KIRKLEES METROPOLITAN COUNCIL INVESTMENT & REGENERATION SERVICE

DELEGATED DECISION TO DETERMINE APPLICATIONS FOR CONSENT, AGREEMENT OR APPROVAL REQUIRED BY CONDITION

Reference No:	2026/44/91411/W
Site Address:	Hinchliffe Mill, Water Street, Holmbridge, Holmfirth, HD9 2NX
Description:	Discharge of details reserved by conditions 4 (design and appearance), 5 (archaeological investigation), 6 (boundary treatments), 9d (flood proofing), 10 (drainage scheme), 15 (Remediation Strategy), 18 (electric vehicle charging), 20 (highway retaining walls, 22 (materials for retaining walls), 24 (Waste Management Plan) and 31 (LEDS) of previous permission 2026/90162 for variation of condition 2 (plans and specifications) of previous permission 2021/90800 for redevelopment and change of use of former mill site to form 19 residential units (within a conservation area)
Recommending Officer:	Victor Grayson

Officer Report

Typical Elevation, Scale 1:20

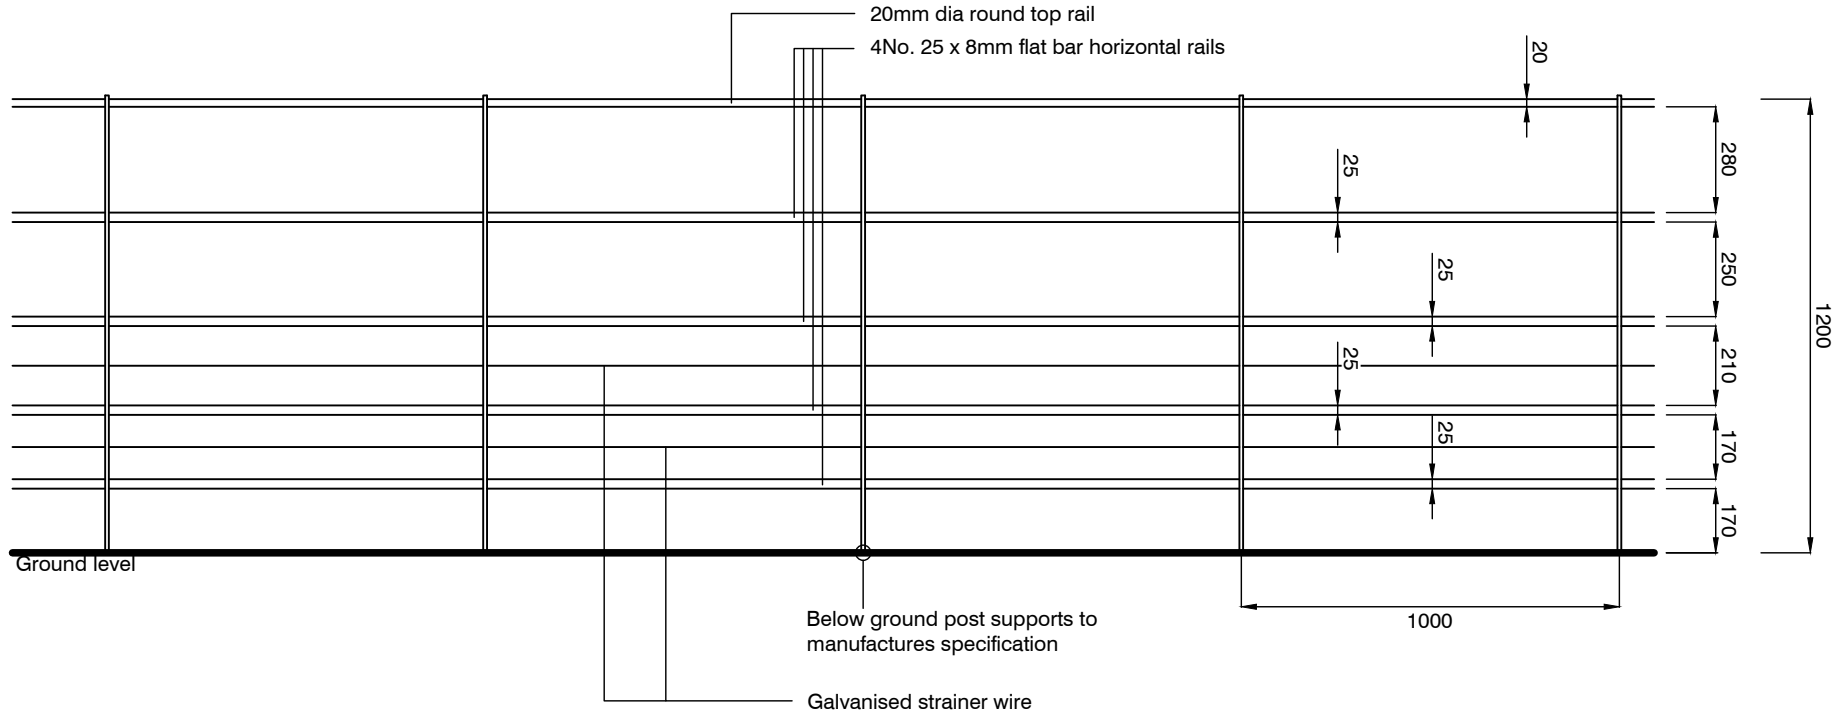
The proposed 1.2m high metal estate railing, painted black, is considered acceptable for this site.

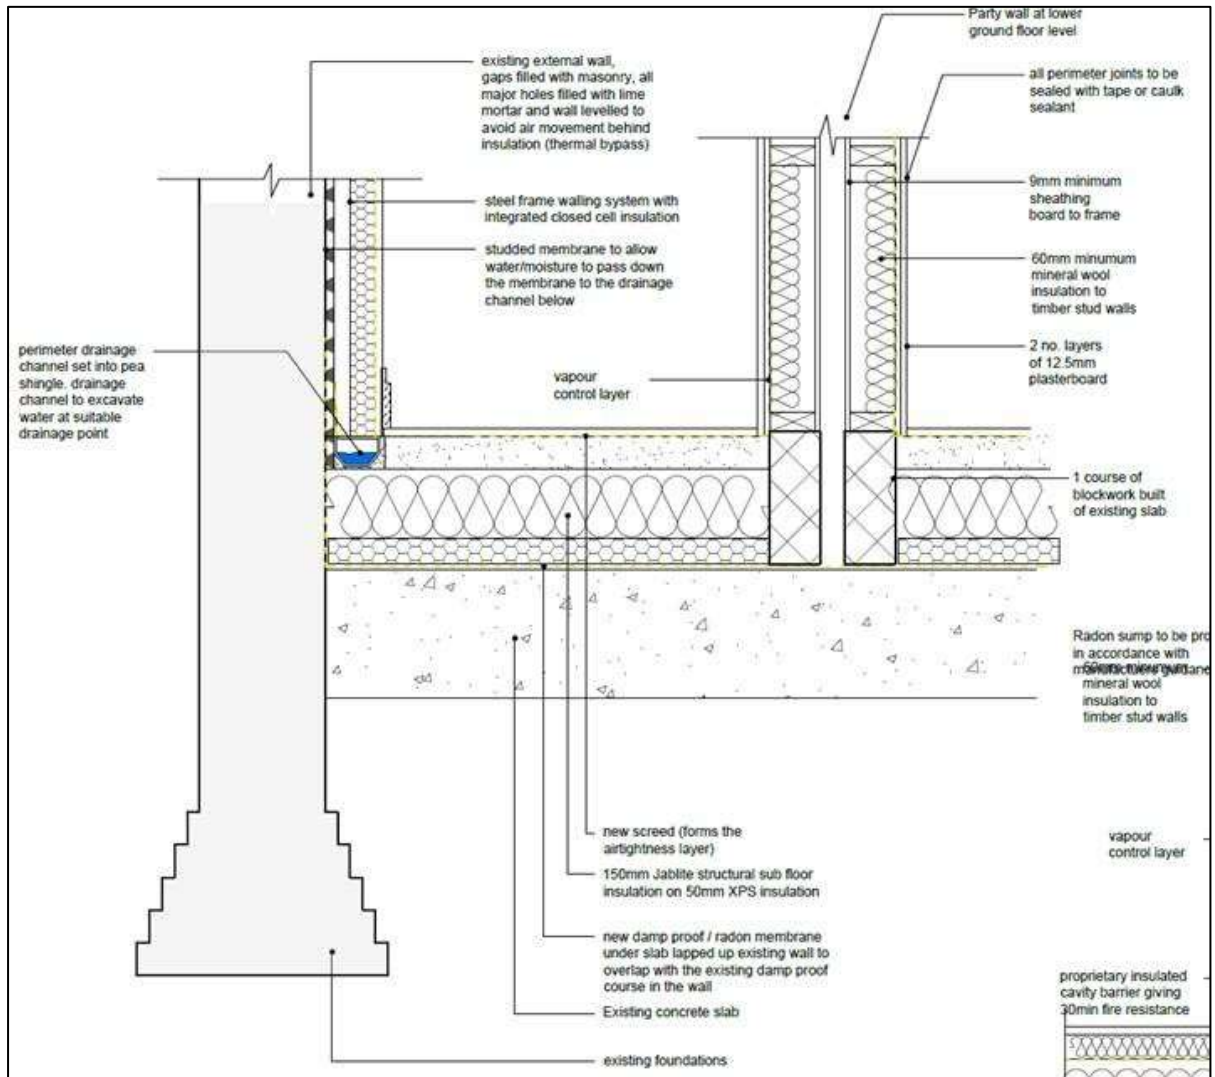
Under this current Discharge of Conditions application, the applicant has stated that the design of the development has been modified so that no groundworks are required below the existing concrete floor slab within the northern section of the mill, and that this means that any archaeological remains that may be present will be undisturbed by the development and will remain preserved in-situ. An accompanying letter (On-Site Archaeology, 24/04/2026) states the same, and appends a section illustrating the retention of the concrete slab.

"...a condition was originally placed on this application for an archaeological watching brief (condition 5) the design of the proposed works has since been changed and the concrete slab under the north side of the mill will no longer be removed. The developers agent has sent a letter to confirm this. Based on this the archaeological watching brief required by condition 5 is no longer required and the condition can be discharged as completed, from an archaeological point of view".

Flood Plan and Hand Over Information

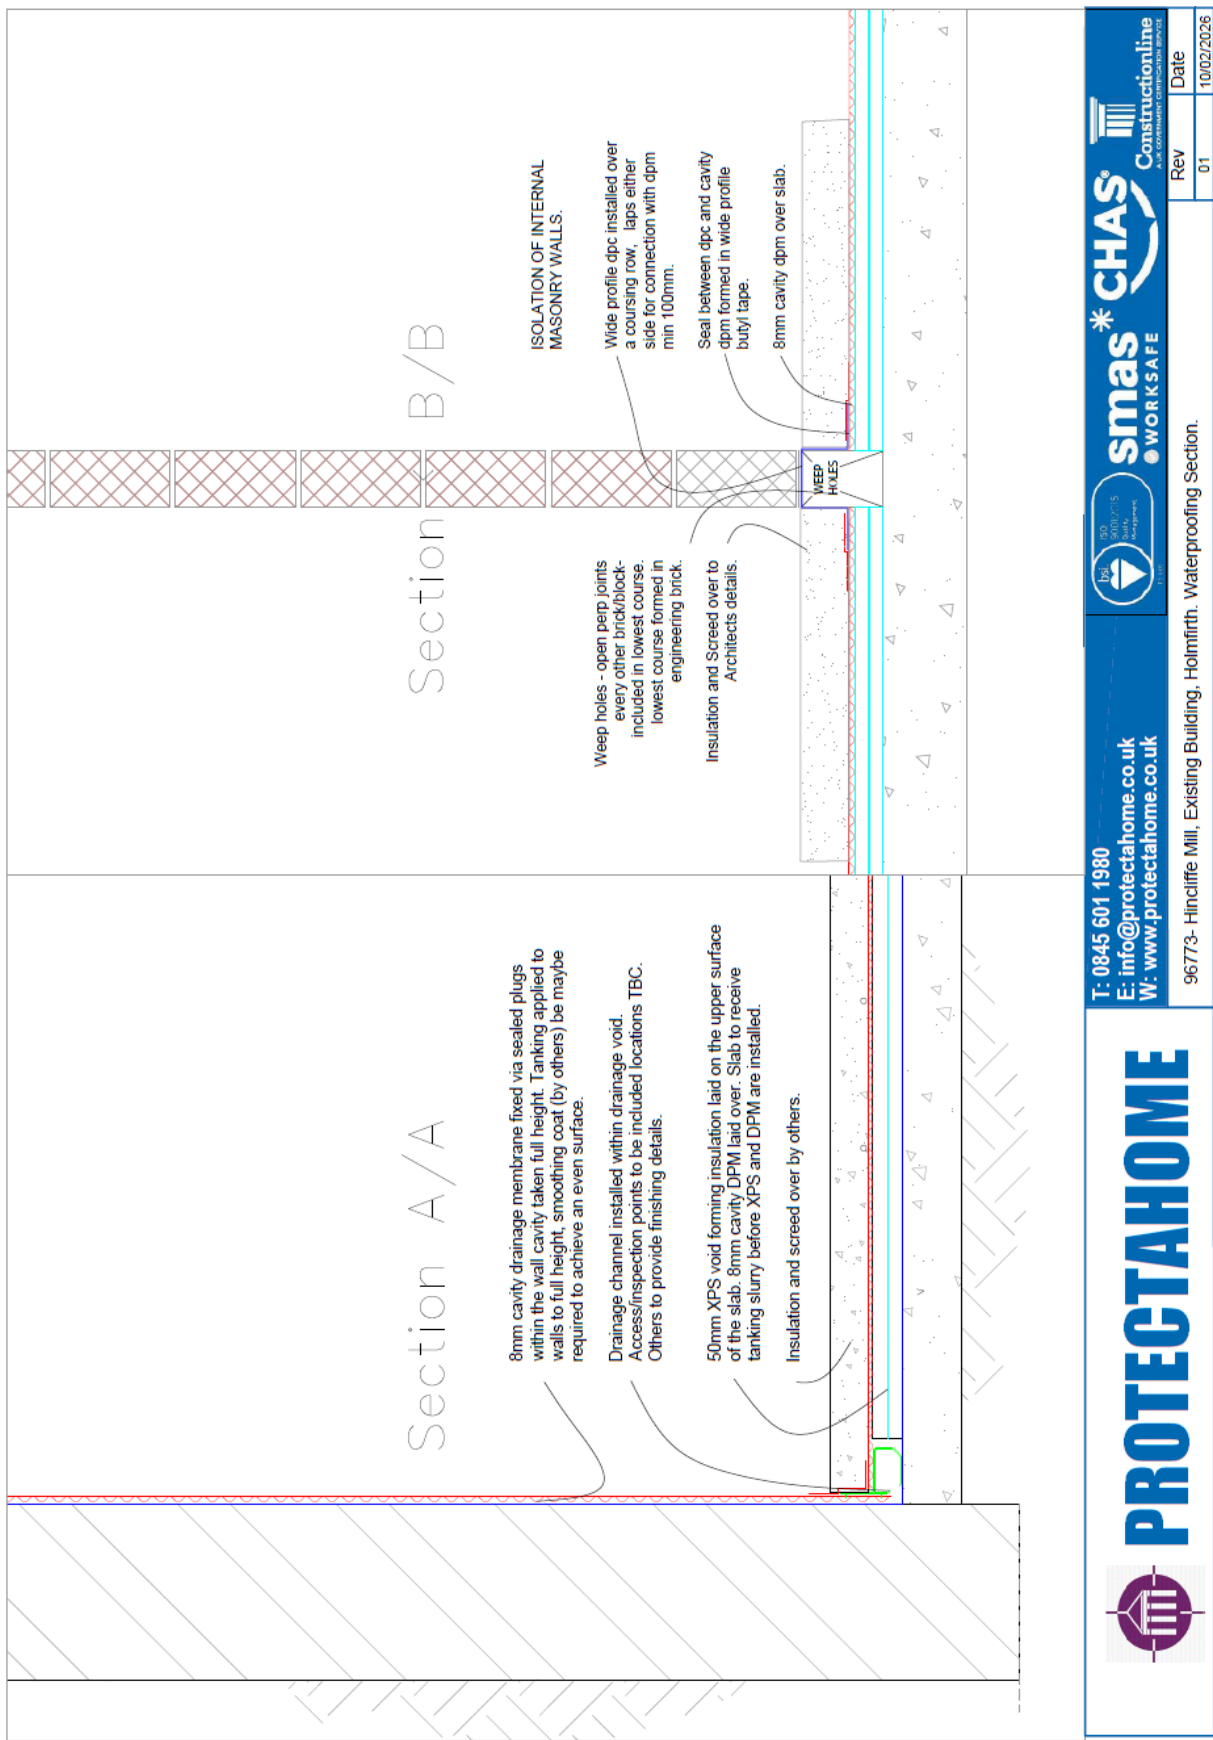
The submitted Flood Proofing Scheme (16/04/2026) is of more use. It proposes no residential living accommodation within the lower ground floors of plots 5, 6, 7, 8 and 9, it sets out sealing and drainage measures, and recommends water resistant materials, one-way valves, raised electrical installations, information dissemination and other measures. Residents will also be advised to sign up to the Environment Agency’s flood alert service. These measures are considered acceptable and proportionate to the scale and nature of development, and to the level of flood risk affecting plots 5, 6, 7, 8 and 9.
